City of Albuquerque Stormwater Construction Site Inspection Report

ESC File No.	M10E020	Project Name:	Kidz Academy and The Human Bean		
NPDES Id. No.	NMR1003NO/NMR1003NP	Location:	7800 Sage Rd. SW		
2/14/2022	Owner	Contractor			
Operator	Kidz Academy and Tres Lobos		Creative Design Builders		
Contact name & title	Keith Griego		Raymond Herrera		
e-mail	kidzacademystaff@gmail.com		rhcdb46@yahoo.com		
Contact Phone #	505-681-7812		505-410-9020		
COA Inspector	Doug Hughes		Start/End Time:	4pm	
Construction Phase:	Vertical				
Type of Inspection:	<input type="checkbox"/> Regular	<input type="checkbox"/> Storm Event	<input type="checkbox"/> Past Storm Event >0.25"	<input type="checkbox"/> 311/Complaint	<input checked="" type="checkbox"/> Follow Up
Weather at time of inspection?	clear		Temperature:	~ 40	
Estimated date of last storm 0.25" or greater	1/1/2022

TEMPORARY EROSION AND SEDIMENT CONTROL PLAN

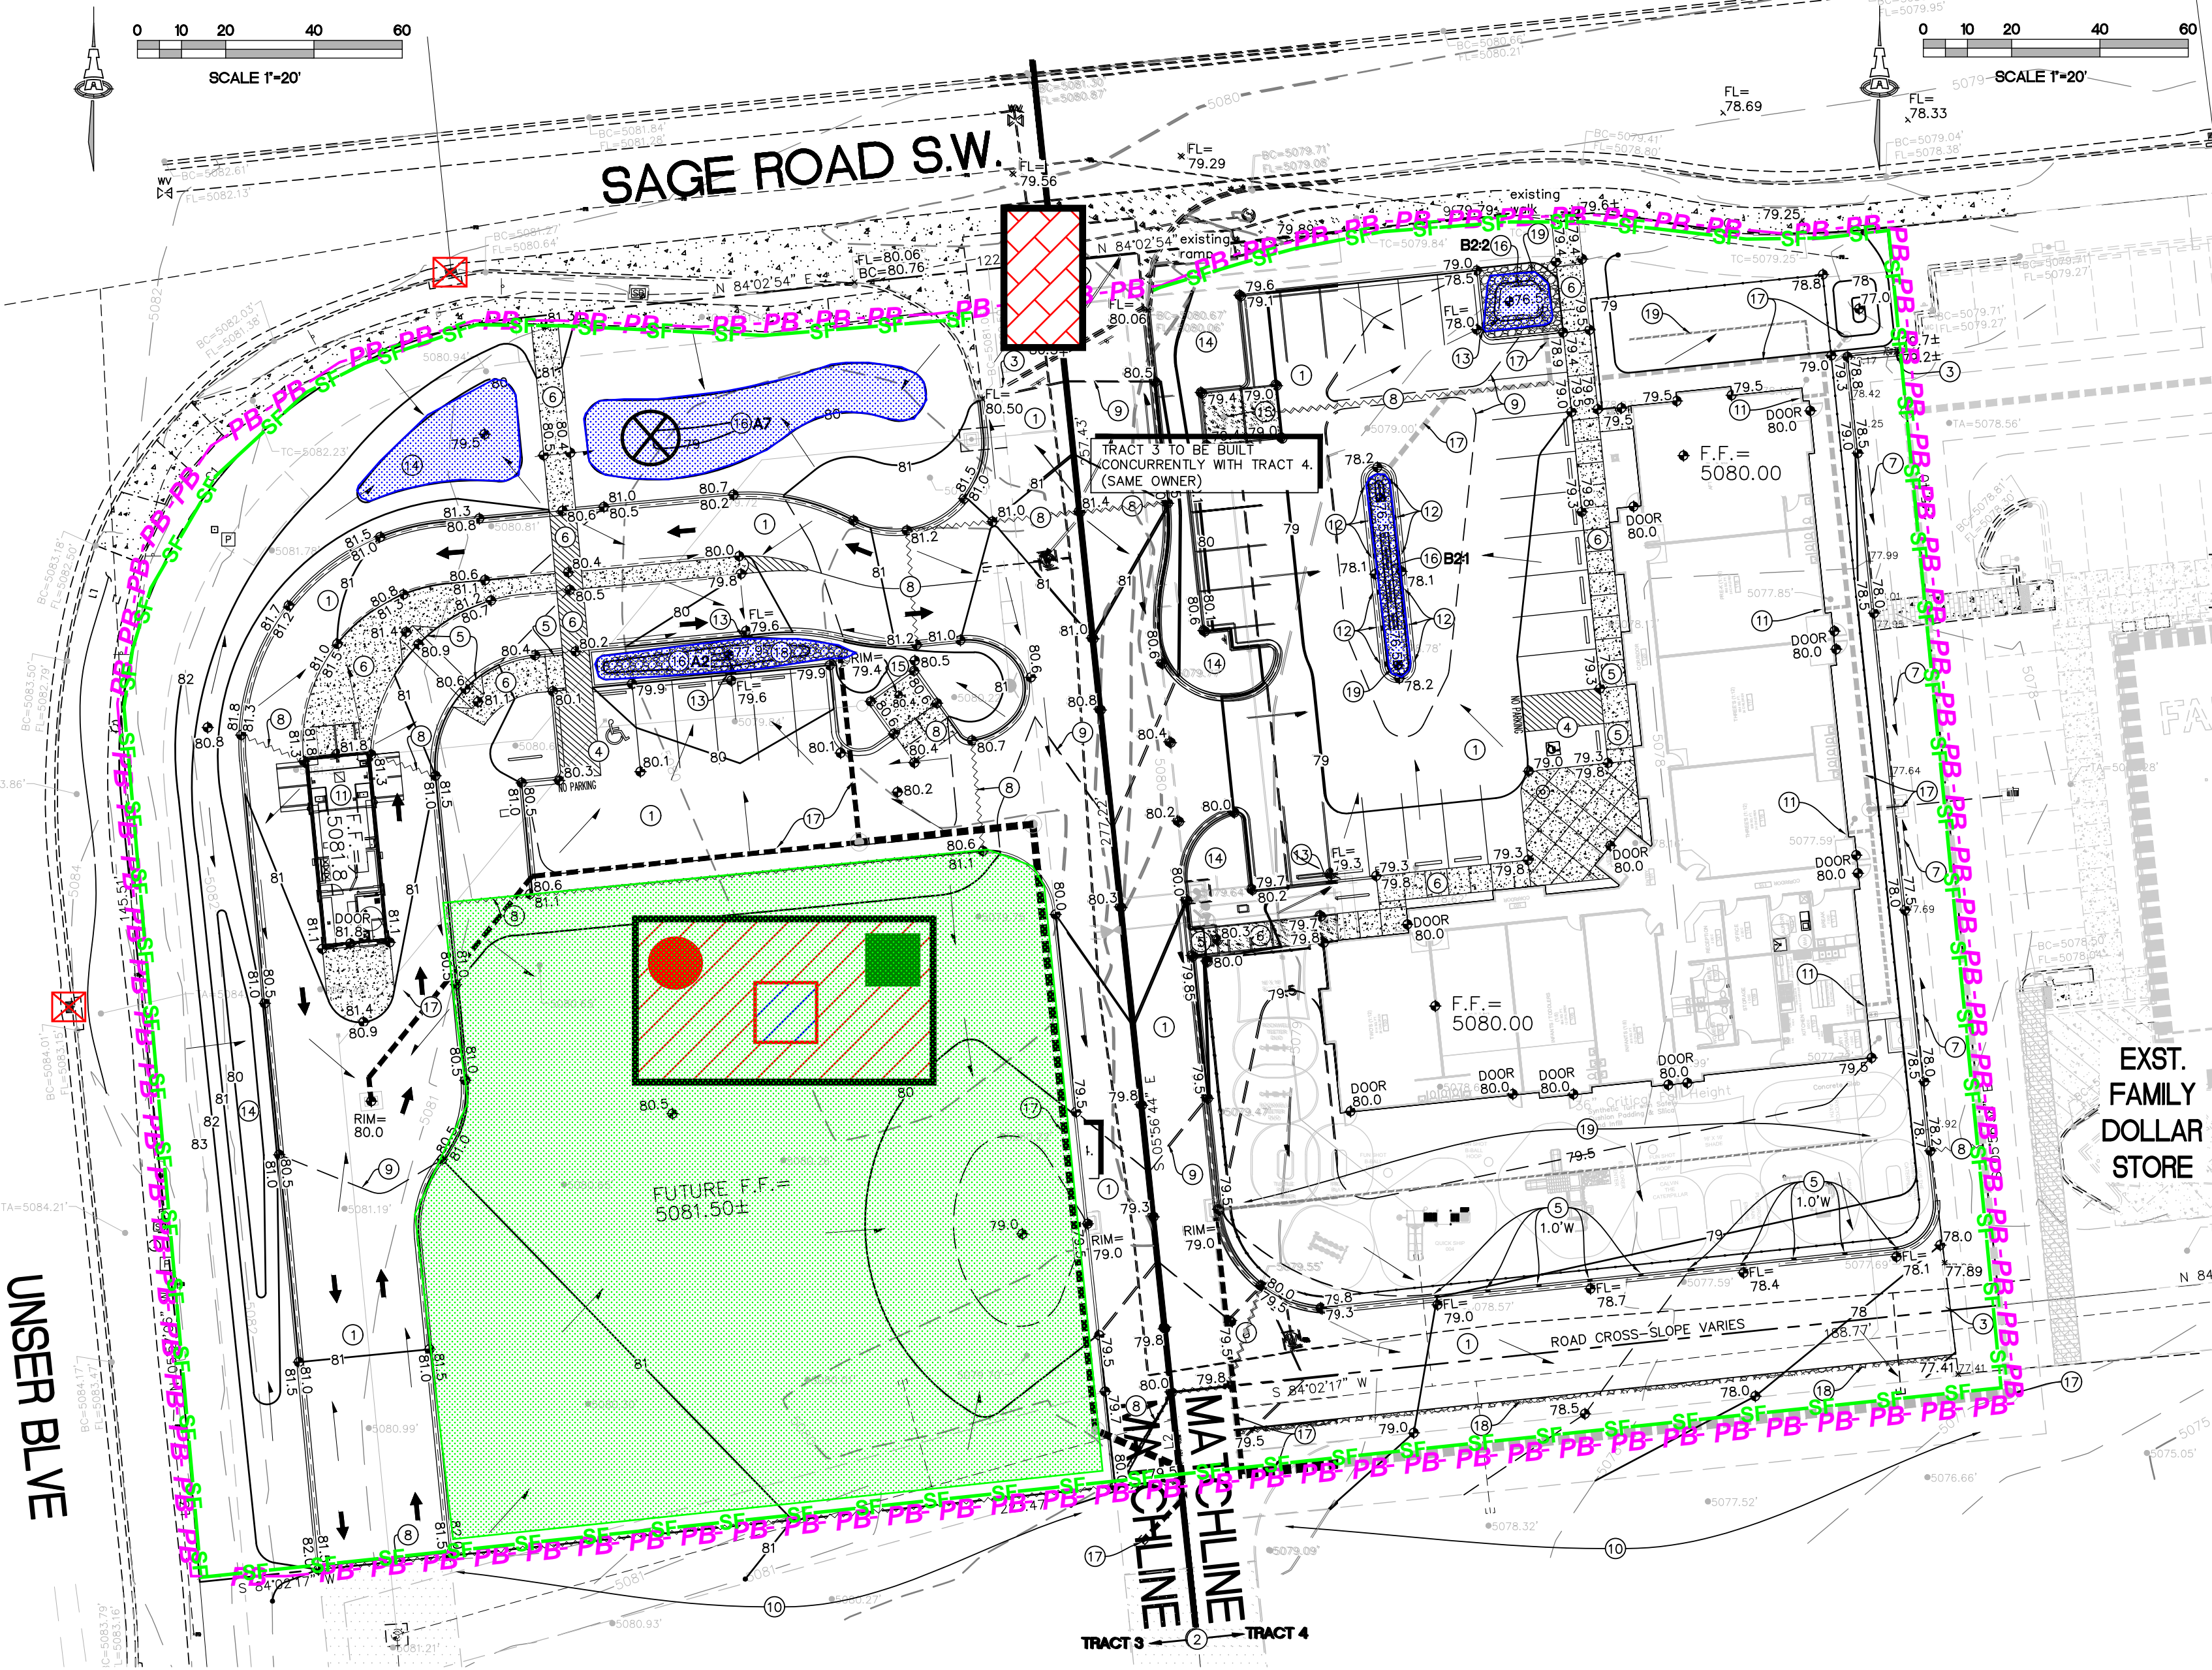
Item Number	Deficiency/ Corrective Action				
1	Inlet Protection in Sage downstream of the site is not maintained and and there is too much sediment in the street upstream of the inlet. Sediment must be removed from Sage and from the parking lot east of Kidz Academy and the inlet protection reset.				
2	Silt fence is missing both onsite and on the south neighbor's property where disturbed.				
3	Cover (SEED AND Mulch) is required in all areas to remain inactive for 14 days or more including dirt between buildings onsite, street frontage, and new disturbance south of south driveway.				
4

Notes:	
Human bean is open for business, Kidz academy is nearly complete. Incomplete stabilization, sediment, and missing BMPs must be mitigated. Progress in mitigating prior violations posting, SWPPP, and waste, so escalation not recomeded this time, but all must be complete at next inspection.
